6 No. residential dwellings & associated infrastructure. This application is a Departure from the Development Plan.

Land east of North End Road & West of Church Lane Nursery Yapton

Thank you for your internet comments made on 12th March 2020 which has been recorded as **'no objection'** with the comments as follows:

4 BEDROOM
SIDE ELEVATION - West
Detached House
Plot 1

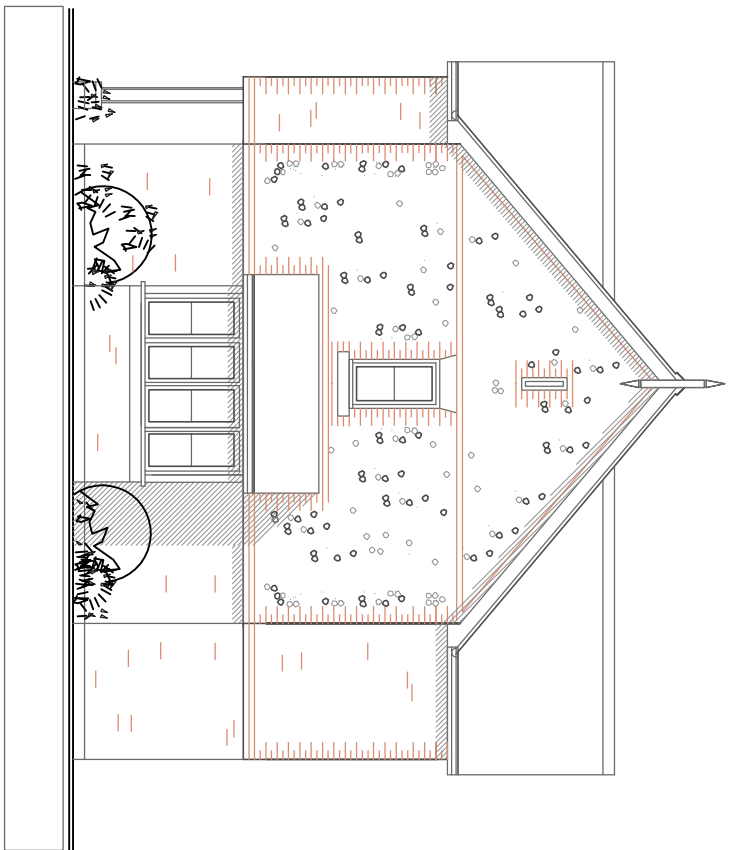
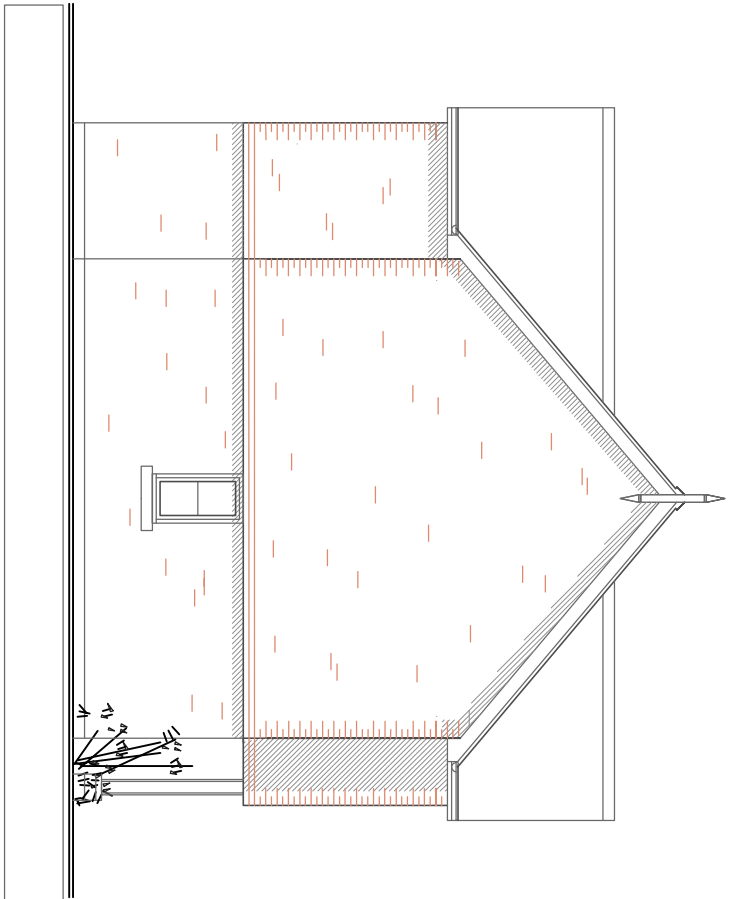
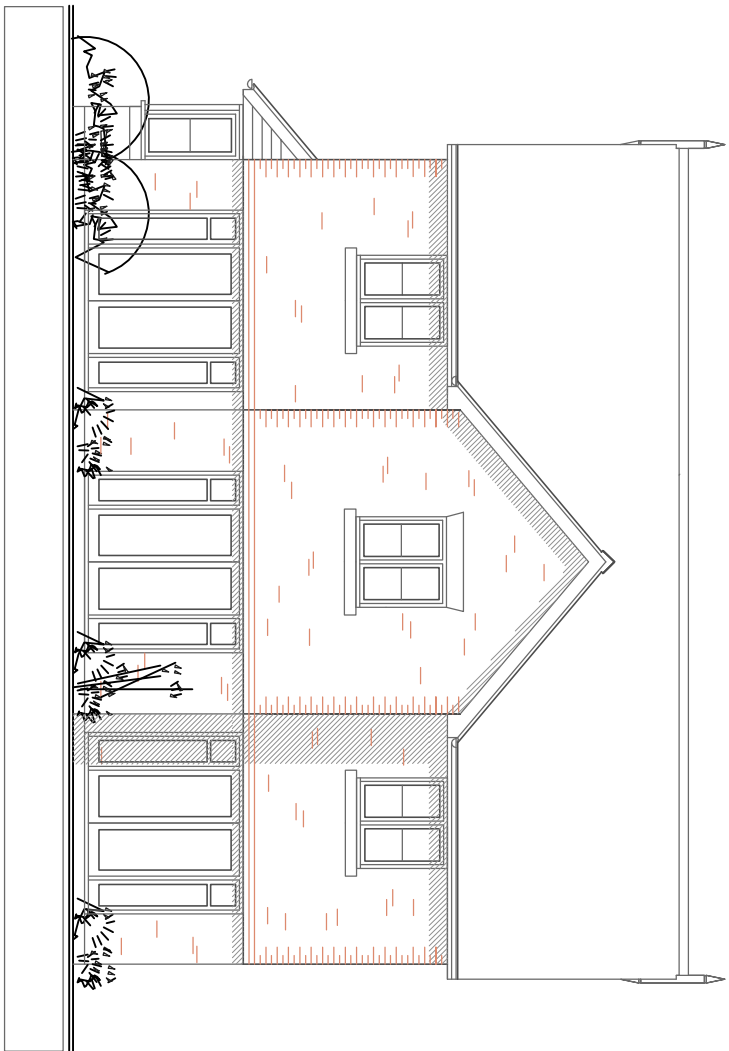
- All materials to be subject to final approval.*
- Plot 1 not to exceed 2 storeys in height to maintain and enhance the mixed street scape of North End Road.*
- The proposed hedging fronting North End Road to be native species which do not have poisonous berries. This is to ensure the hedge enhances the scheme and does not place primary school children walking to school at risk.*
- The developer to protect the existing wide grassed verge fronting North End Road and extending to Church Lane by installing small 0.5m high bollards to prevent verge side parking. This will ensure the safety of any pedestrians using the pavement and the protection of the grass verge. YPC note that WSCC have recently released a statement confirming that they will not be replacing bollards such as the ones missing along this stretch of verge leaving residents and the Parish with the responsibility of finding a*
